**RE: Precision Eye Center
7521 Alameda Blvd. NE
Grading & Drainage Plans
Engineer's Stamp Date: 04/19/23
Hydrology File: C19D070**

Re: C19-D070 Responses to Hydrology Comments received on 3/16/2023

**RE: Precision Eye Center
7521 Alameda Blvd. NE
Grading & Drainage Plans
Engineer's Stamp Date: 02/28/23
Hydrology File: C19D070**

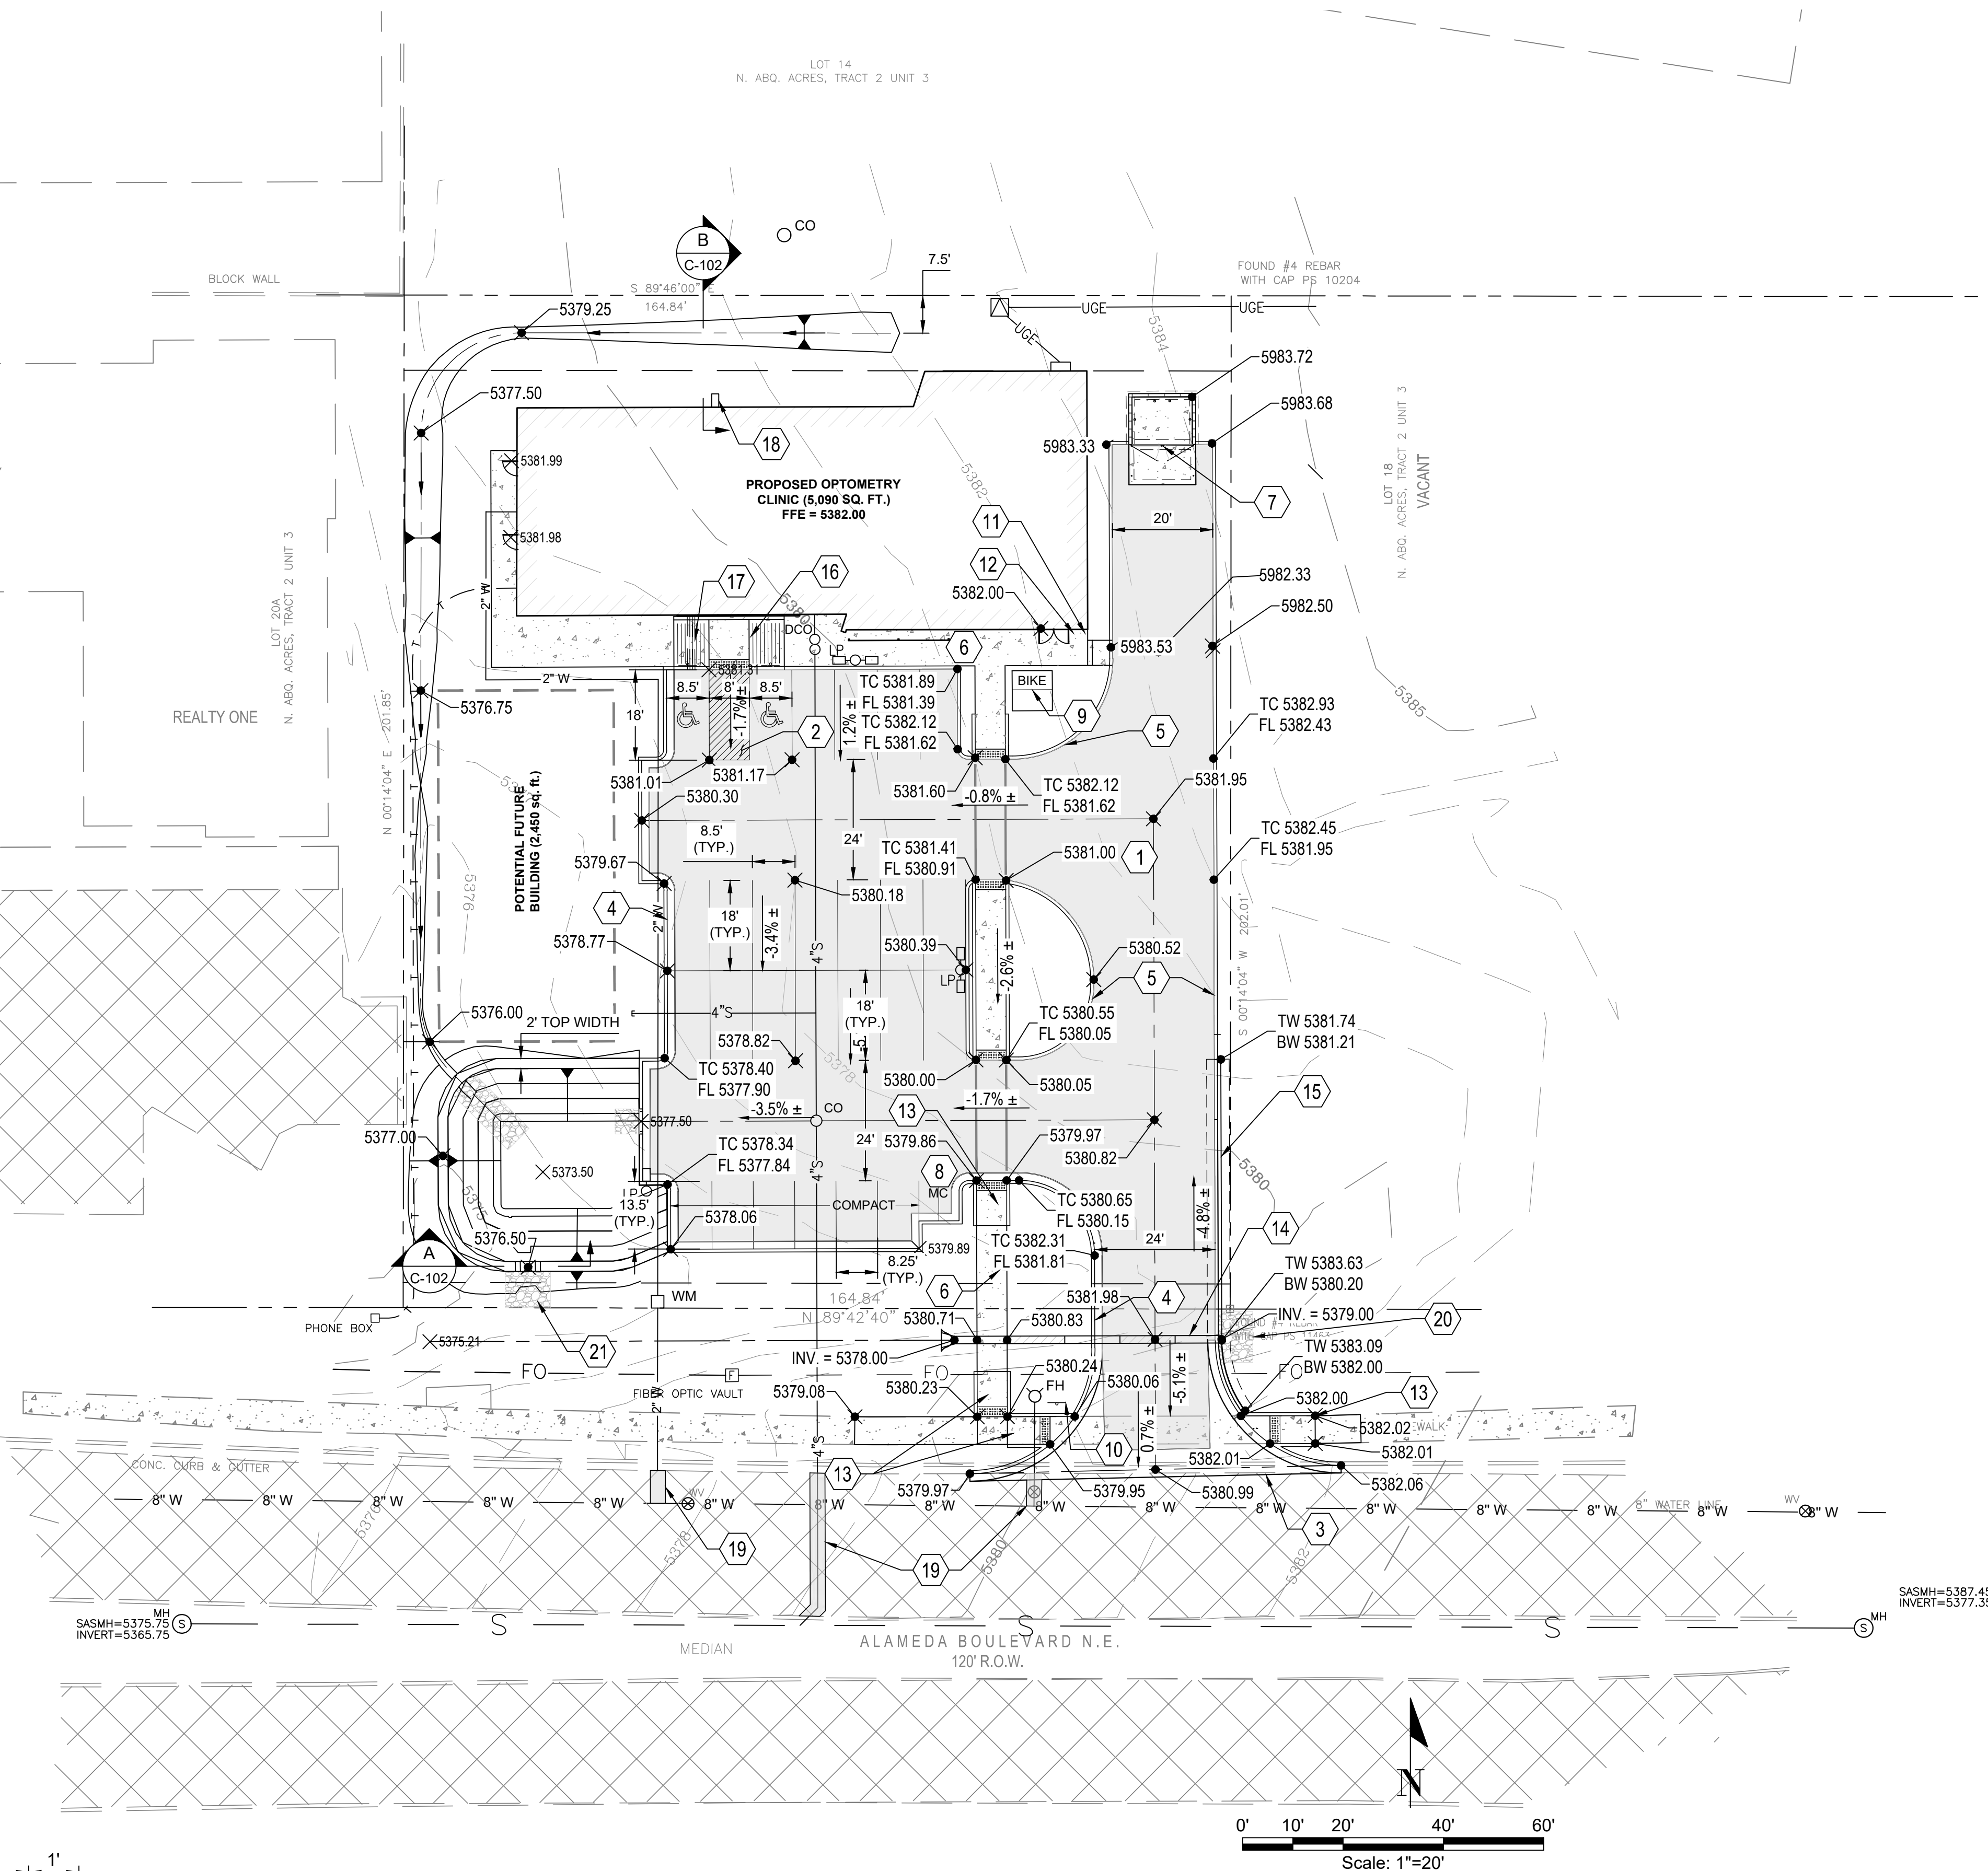
7. On Sheet 102, please provide a sidewalk culvert for the spillway for the stormwater quality pond to Alameda Blvd. and label per CoA Detail 2236. Please also show the invert at the pond (this is the SWQ water surface elevation) and the invert at the existing gutter on Alameda Blvd. **sidewalk culvert with riprap rundown added**
